**Planning Department  
Transportation Development Services**

**Re: Albuquerque Rescue Mission, 214 Coal Ave. SW  
Traffic Circulation Layout**  
Architect's Stamp dated 07-21-14 (K14-D057)

RE: **Albuquerque Rescue Mission, 214 Coal Avenue SW**  
**Traffic Circulation Layout**

① TRAFFIC CIRCULATION LAYOUT
1" = 20'-0"

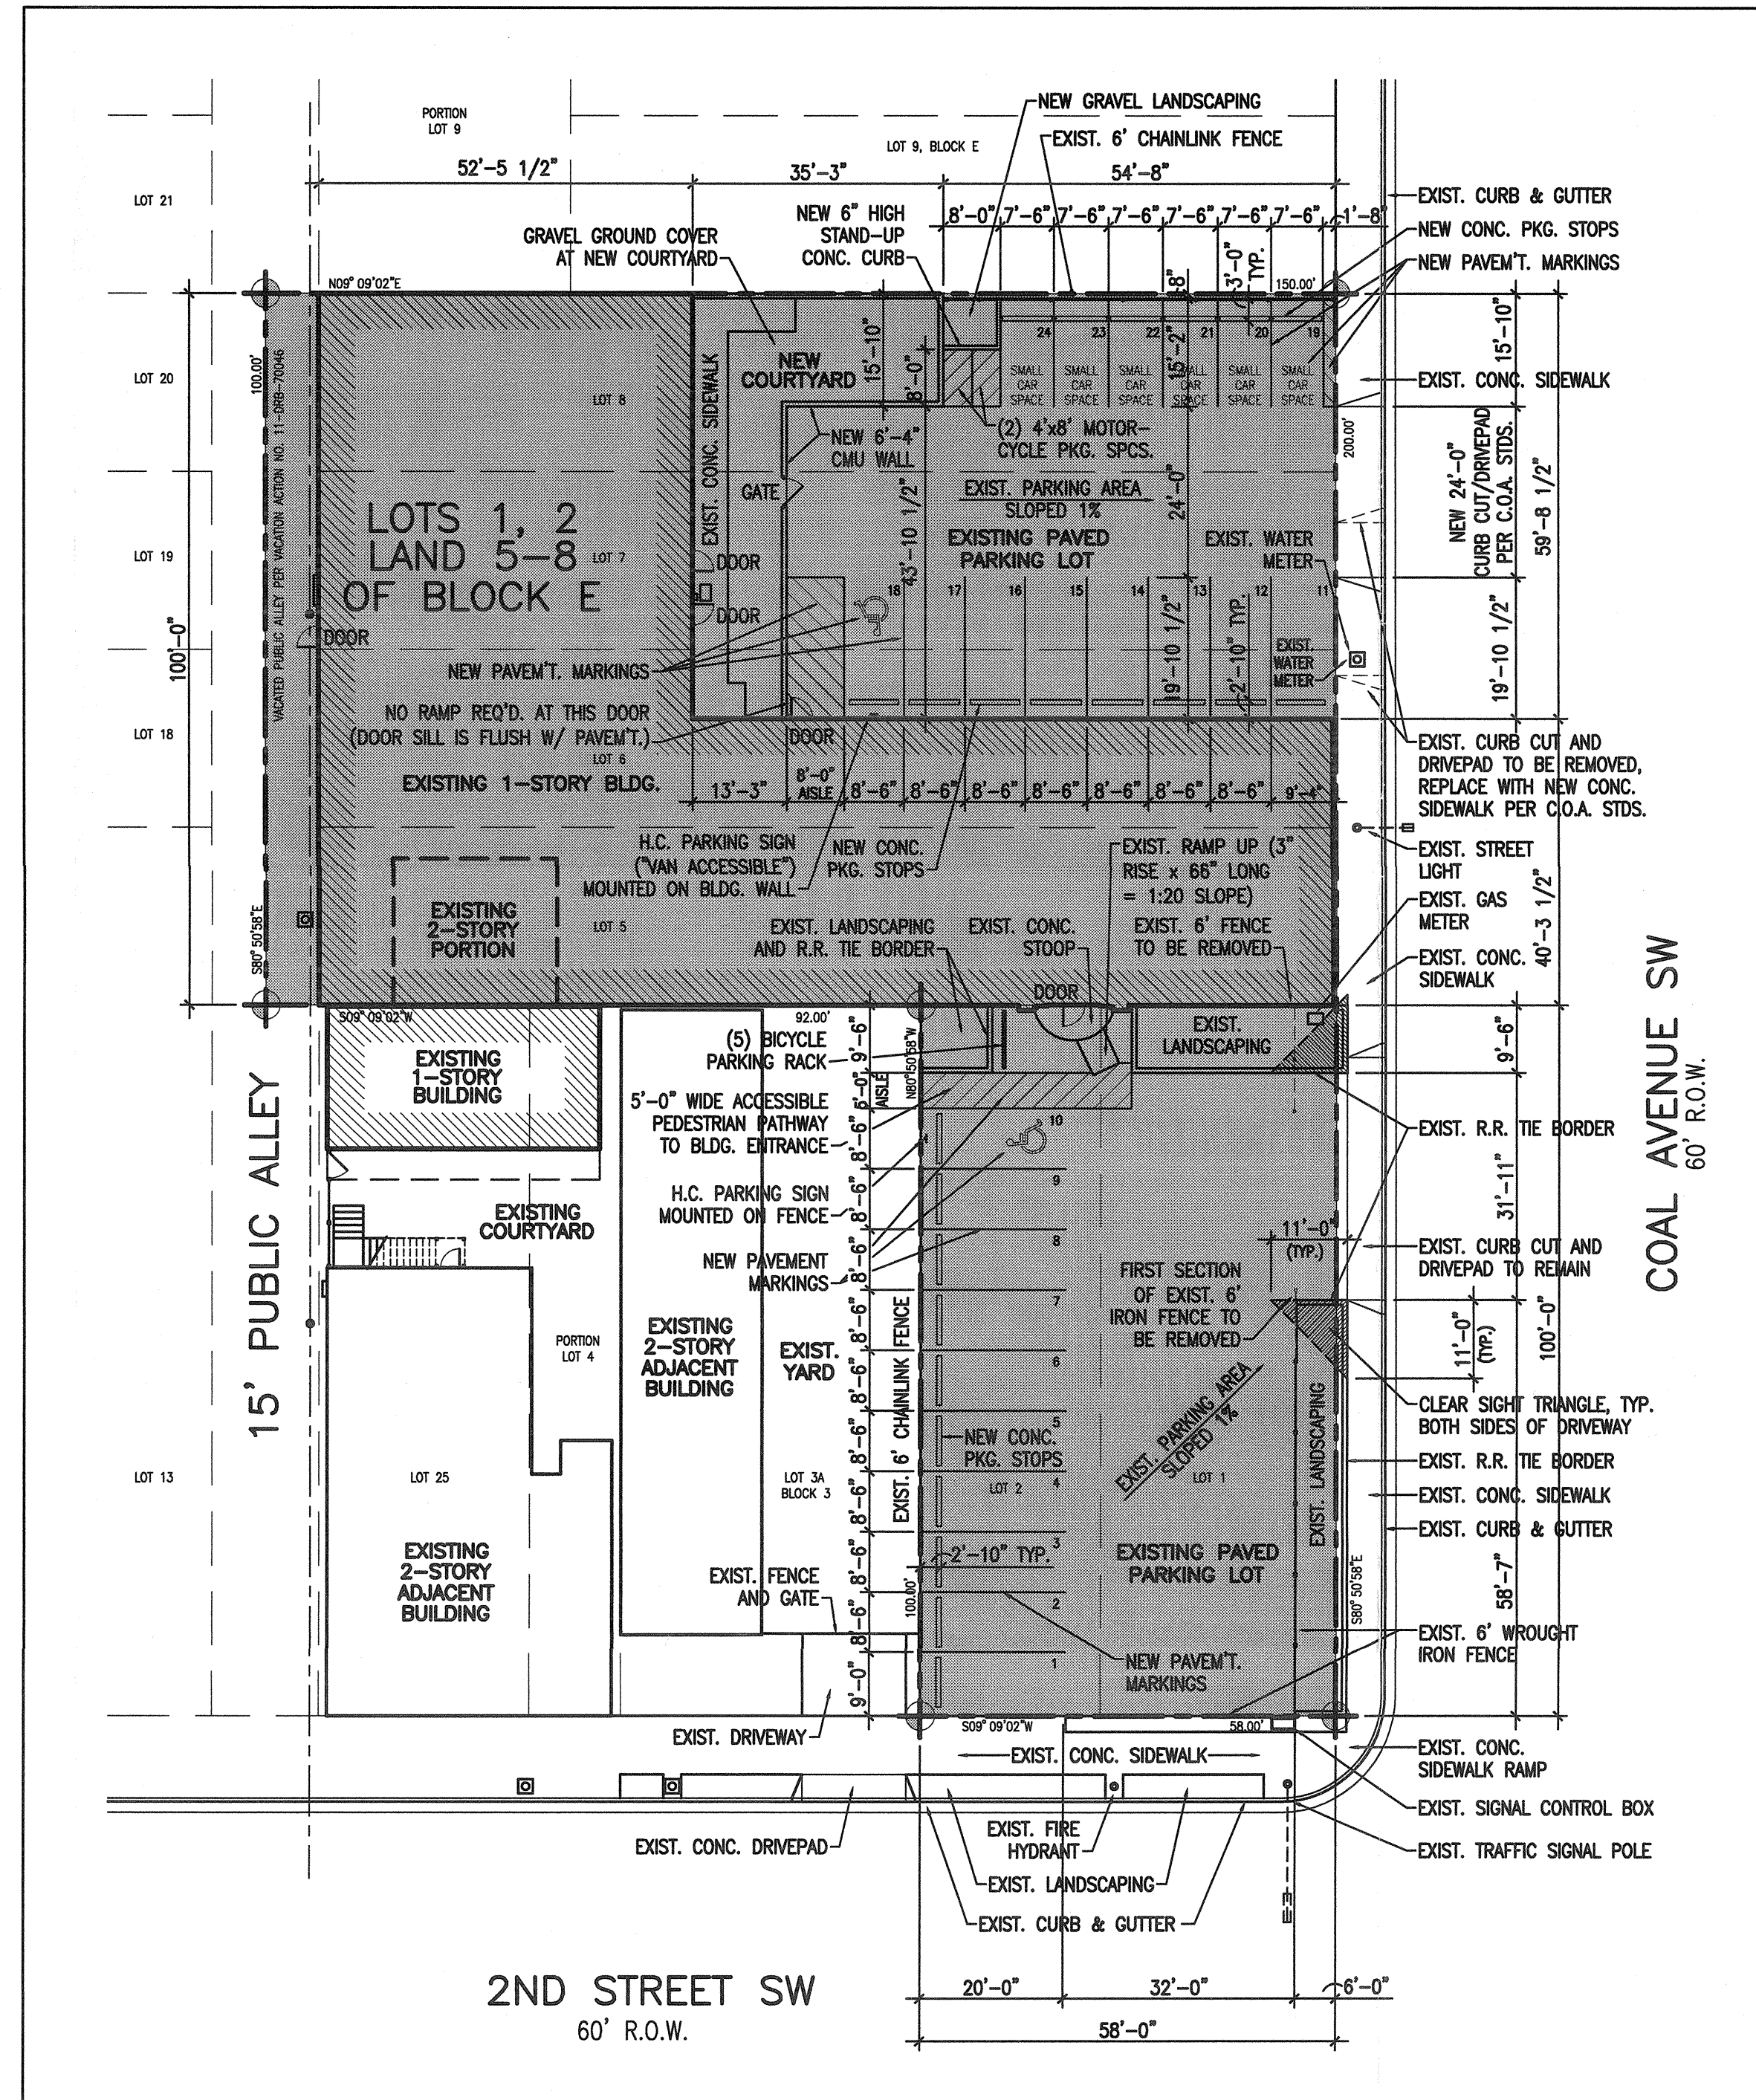
1. Handicapped spaces are designated with 8.5' widths. The HC space on the west side of the building includes an 8' wide van access aisle and "van accessible" sign, the HC space on the east side has a 5' aisle.

2. The HC space on the west side has a "van accessible" sign.
3. The allowable space for this parking lot remodel will allow a 5' wide ADA accessible pedestrian pathway to the building entrance, but there is not sufficient space for a 6' wide pathway.

4. The existing ramp on the east side is a 1:20 slope which is under the 1:12 maximum requirement. The sill of the entrance door on the west side is flush with paving outside the door, so no ramp is required at that door.

5. Clear sight triangles have been added to the east drive pad, and some existing fencing is shown to be removed to meet clear sight triangle requirements.

6. The clear sight triangle note has been added to the TCL drawing.
7. Two stamped copies of the updated TCL are attached.
